29 June 2020

**SSD 10434, RELOCATION OF EXISTING SCHOOL - 125 DONNISON STREET & 171 MANN STREET GOSFORD (Lot 11 DP746819 & Lot 100 DP1220146) – ENVIRONMENTAL IMPACT STATEMENT**

TfNSW have reviewed the Environmental Impact Statement, prepared by Mecone Pty Ltd, and dated June 2020, including Appendix 3 Transport Impact Assessment (TIA) prepared by GTA Consultants and dated 9 May 2020.

Proposed Erina Street Elevation

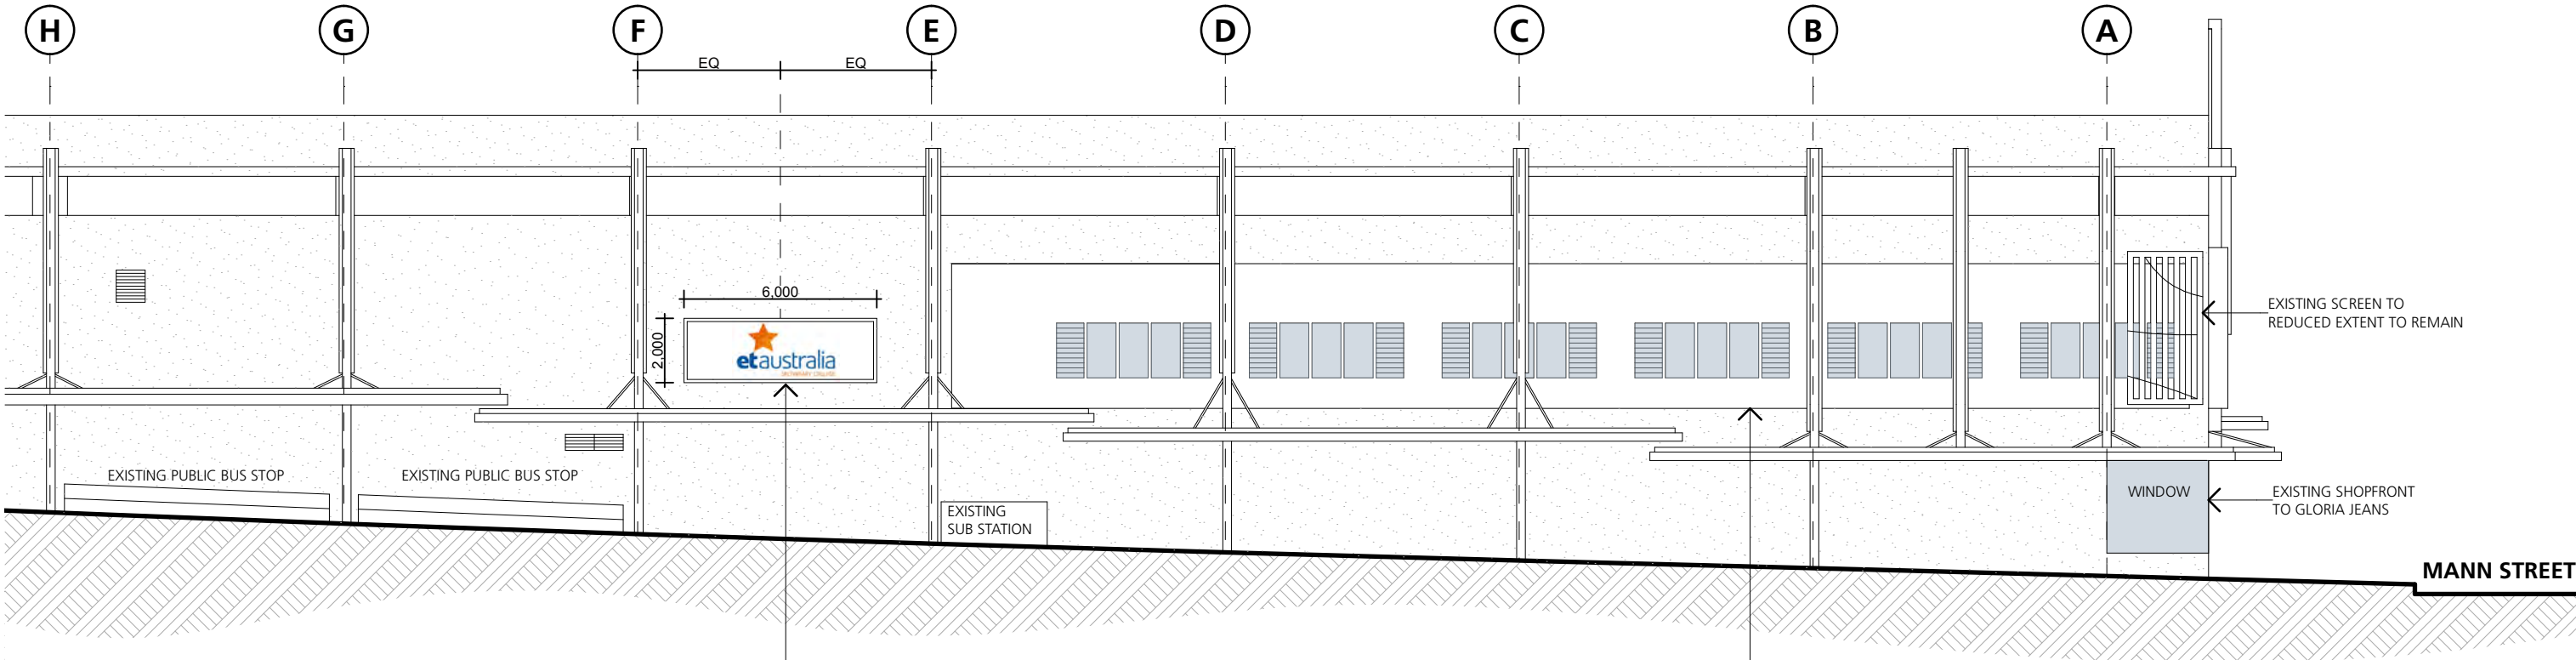
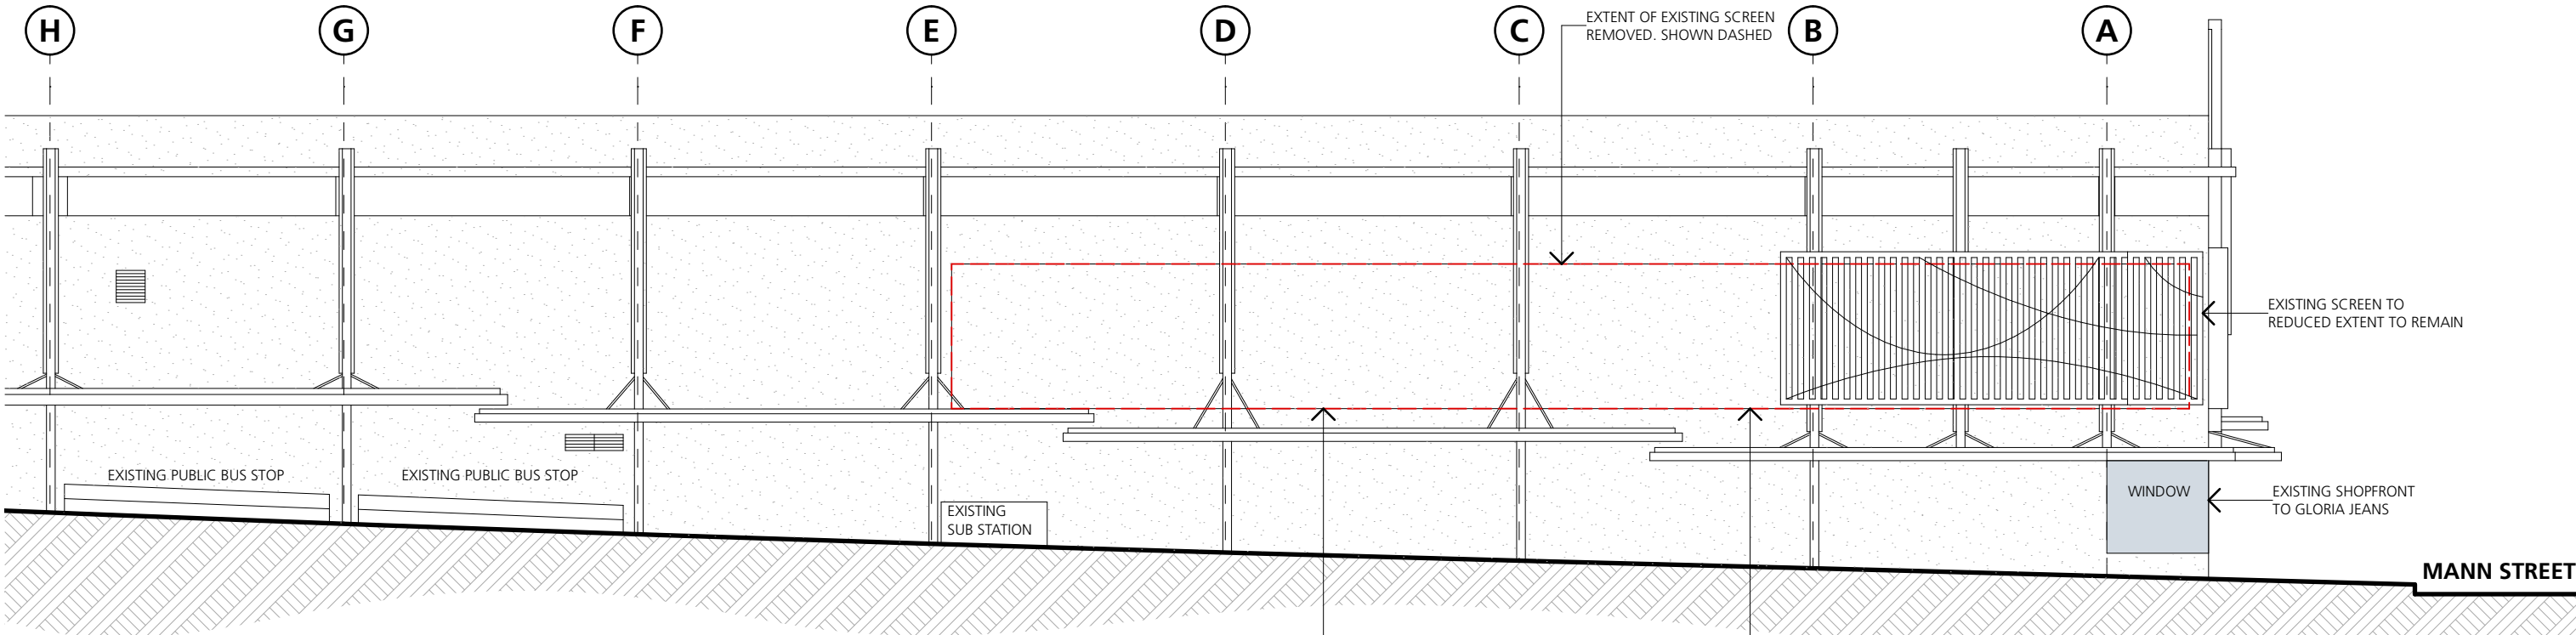
- While it is acknowledged that concurrence is not required to be provided by TfNSW for the new signage proposed in the subject application under Clause 18 of the State Environmental Planning Policy 64 (SEPP 64), the following advice is for DPIE/Consent Authority to consider:

- All signs should meet the criteria contained in the Department of Planning's TfNSW Corridor Outdoor Advertising and Signage Guidelines (November 2017) including, but not limited to, Section 3.3.3 Illumination and reflectance.

- DPIE/consent authority should ensure that all signs meet the requirements of Schedule 1 Assessment Criteria of the State Environmental Planning Policy (SEPP) No. 64 – Advertising and Signage.

- Please advise the applicant that TfNSW may direct the screening, modification or removal of a structure if, in the opinion of TfNSW, the structure is considered a traffic hazard under Section 104 of the Roads Act 1993.
